REQUEST

Approximately 10.26 acres located on Shopton Road between Steve Chapman Drive and Pinecrest Drive.

The petition proposes to amend a previously approved plan to add a parcel, list additional prohibited uses, and expand to 120,000 square feet of office, warehouse, and distribution uses and outside storage.

PLANNING STAFF REVIEW

Plotted By: Watts, Austin Sheet: Set Shopton Rezoning - Layout-RZ-1 TECHNICAL DATA SHEET March 20, 2023 06:28:13pm K:\CHL\PRJ\015272_AAC\048 Shopton Road Industrial\02 - DWG\PlanSheets\Rezoning\RZ-1 TECHNICAL DATA SHEET.dwg

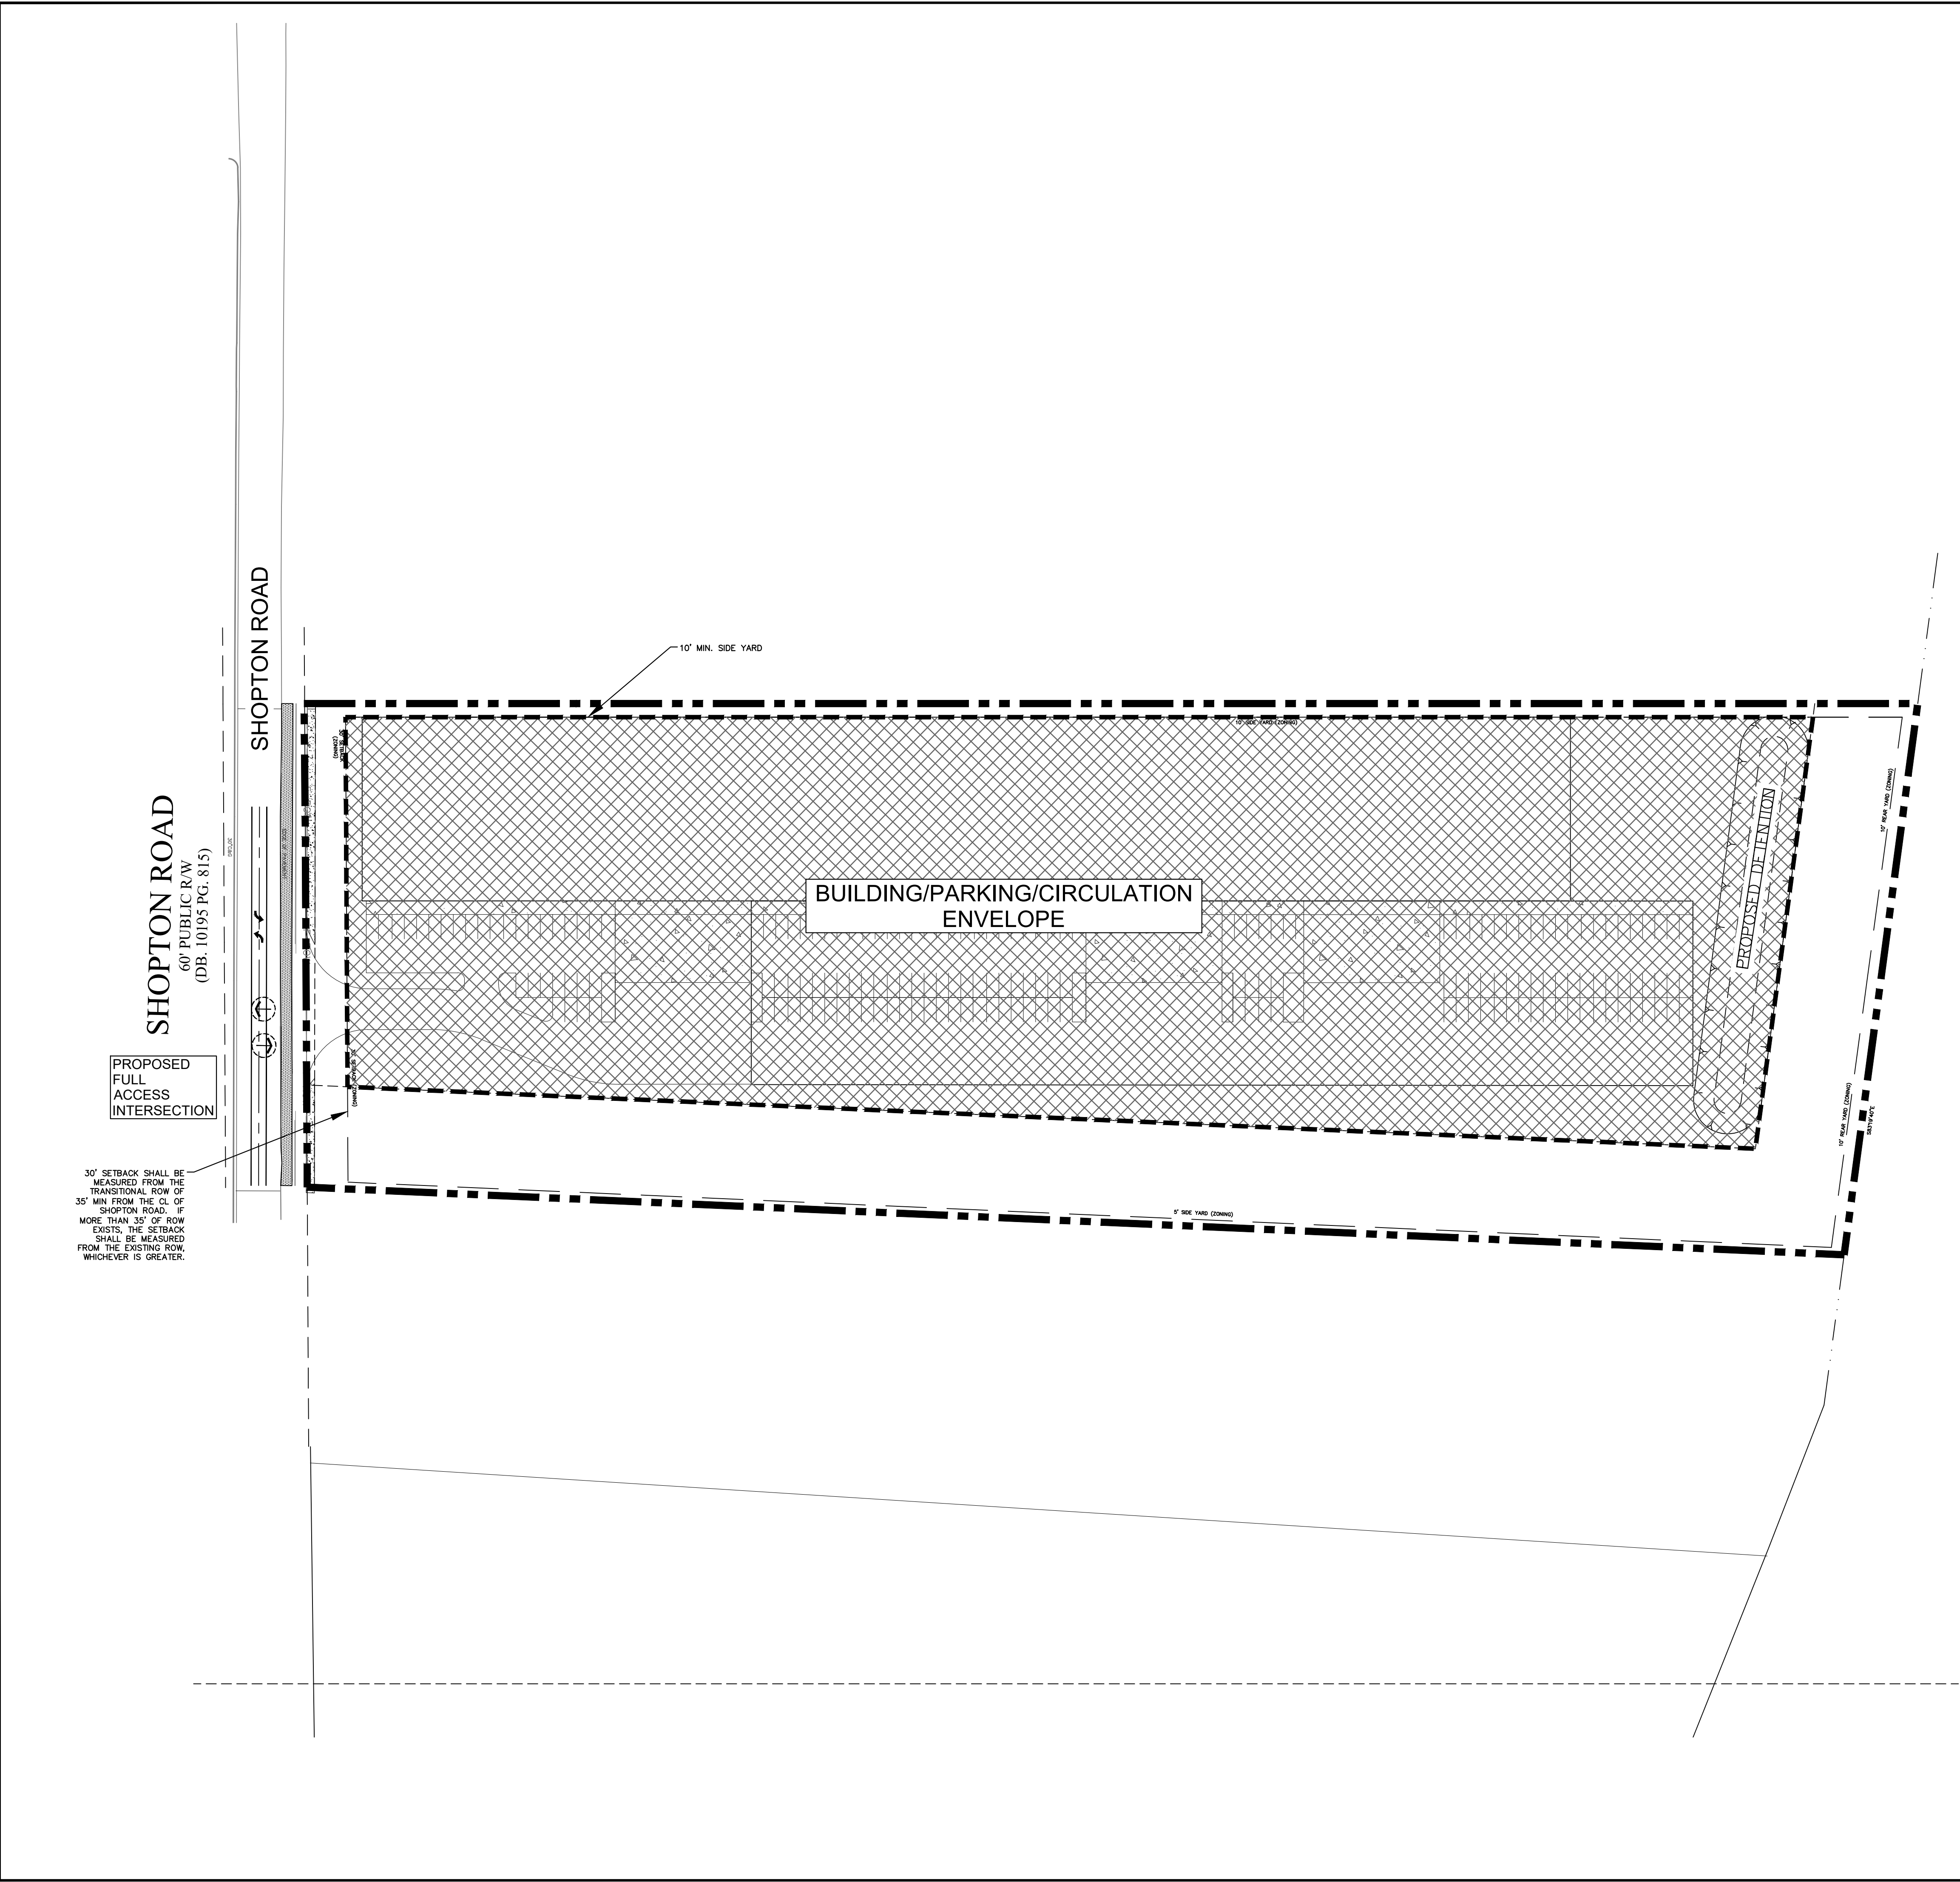
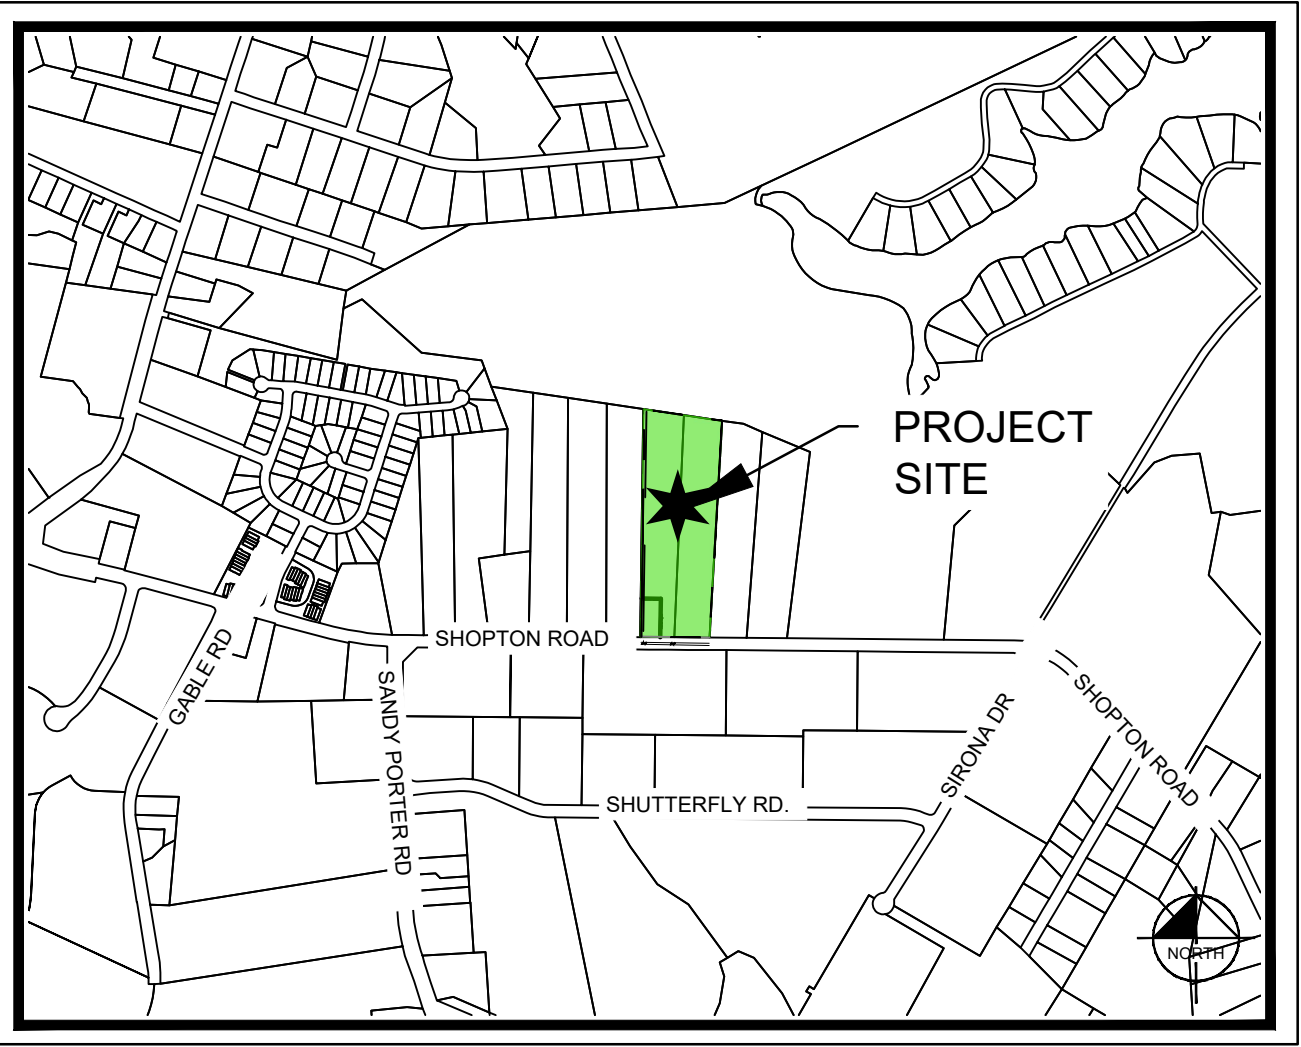
- ~~1. Label and dimension the curb and gutter at 27' from the centerline of Shopton Road on the site plan.~~
ADDRESSED
- ~~2. Revise site and plan and conditional notes to commit to constructing an 8' planting strip and 8' sidewalk as specified in the Charlotte Walks policy.~~ ADDRESSED
- ~~3. Add a conditional note that the entire sidewalk must be outside of the right of way and within a public access easement. Add a conditional note committing to construction and maintenance of the 8' sidewalk on Shopton Road.~~ ADDRESSED

- ~~4. Delete all items that were applicable to the previous petition but not to the current petition.~~
ADDRESSED
- ~~5. Illustrate on the site plan right of way at 35' from centerline and 20' setback. Remove hatching from area within the setback. No use or parking and maneuvering are permitted within the setback.~~
ADDRESSED
